Your Ref: OWPC23823
Our Ref: AL/51/19/PL 05-06-2019
Please ask for:
Mr S Davis

Demolition of the existing dwelling & erection of 3 No 2-bed, 3 No 3-bed & 4 No 4-bed dwellings, access, landscaping & associated works.

Springfield and land to rear Hook Lane Aldingbourne

Fig 7 - Proposed Site Layout Plan

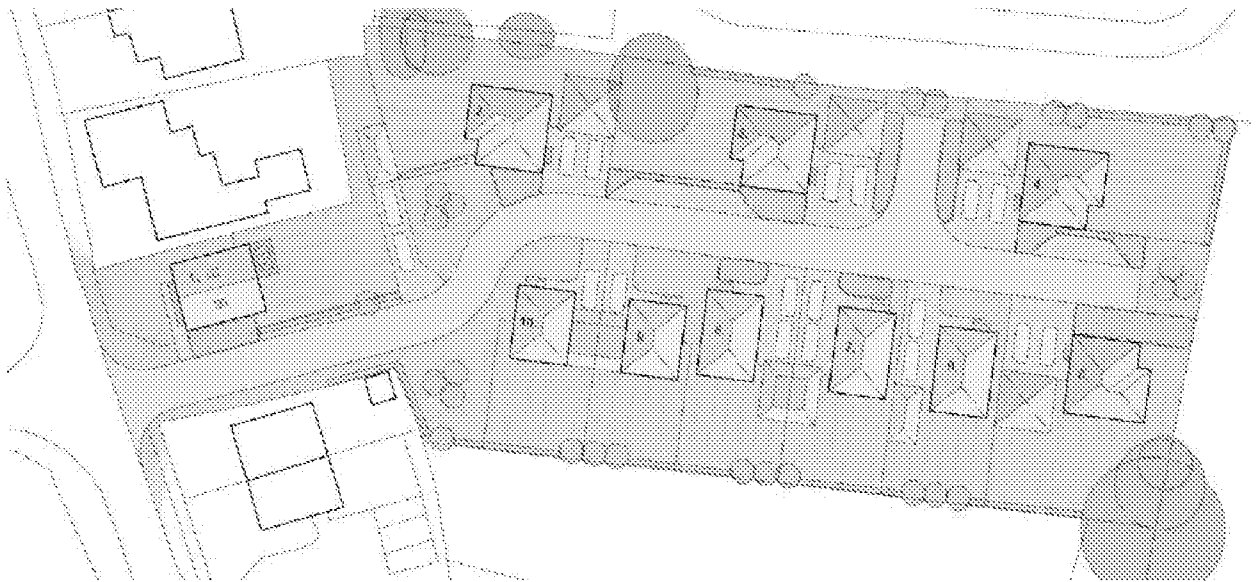
- There is a Culvert/Watercourse on the northern edge of the proposed development that is directly opposite the front of our house and 5 metres from our property. This seems to be very close to Plots 3/4 and garages of the properties. Proposals appear to be to build within 3 metres of the culvert which Laura Gibbons has advised in her e mail must not happen?*

- What considerations have been made for fencing to separate the proposed development from The Furlongs which is an un-adopted area by the council with costs to maintain the site paid by the residents. Plot 3 will be located directly in the front of our property and looking at the Proposed Block Plan SK01 and Elevation Plan SK08 both the lounge window and the kitchen window will look directly into our house affecting our privacy. We would like either trees to remain in situ to block this line of sight or the windows to be behind a suitable fence for the property.*

infilled with a 5-metre buffer. There are numerous hedgerows on the northern edge of the development as stated in the Arboricultural Impact Assessment Report (point 2.2 within the report). Liz Annals has advised a 5-metre buffer strip must be in place around these hedgerows. Looking at the Proposed Block Plan SK01 it seems the location of Plots 3/4 along with their garages are within 5 metres of the hedgerows in this location and therefore within the buffer zone?
